Application No: K/16/21/HH  
Site Address: Sea Lodge 7 Coastal Road Kingston BN16 1SJ  
Description of works: Internal alterations to existing dwelling. Demolition and replacement of existing rear extension with new single storey extension and first floor terrace above with external staircase. Replacement of main roof and 4no. new dormers with windows. Replacement roof tiles to single-storey projections on North elevation. Proposed rear single storey minor extension to garage to form entrance lobby. Alterations to external facade of house and replacement windows and doors throughout. Associated landscaping to suit.

Thank you for your internet representation made on 16th June 2021 which has been recorded as an objection with the comments as follows:

Project Coastal Road Drawing Proposed Second Floor	Project No. 2107 Dwg No. 3.102 Scale 1:100 @ A3	Rev Date Notes </
--	---	--

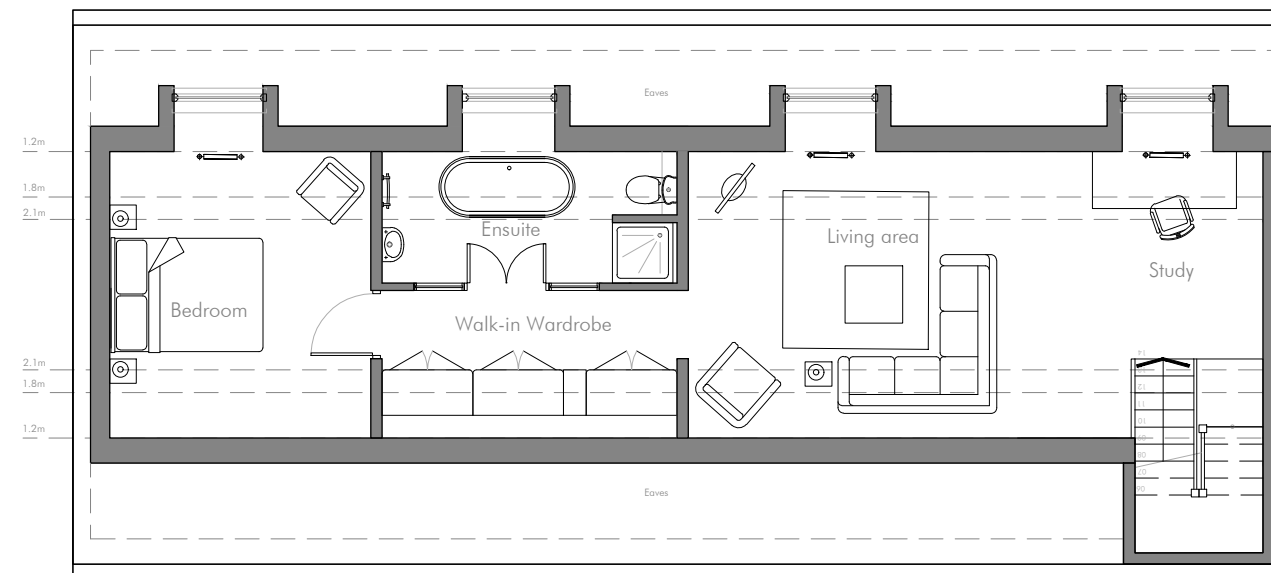
the additional one metre plus in height of the roofline and new bedrooms:

It will cause significant shadowing to my main first floor and ground floor terraces (which have seating and dining provision) as well as pose a clear invasion of privacy to both areas.

Both are used extensively and are currently not overlooked .
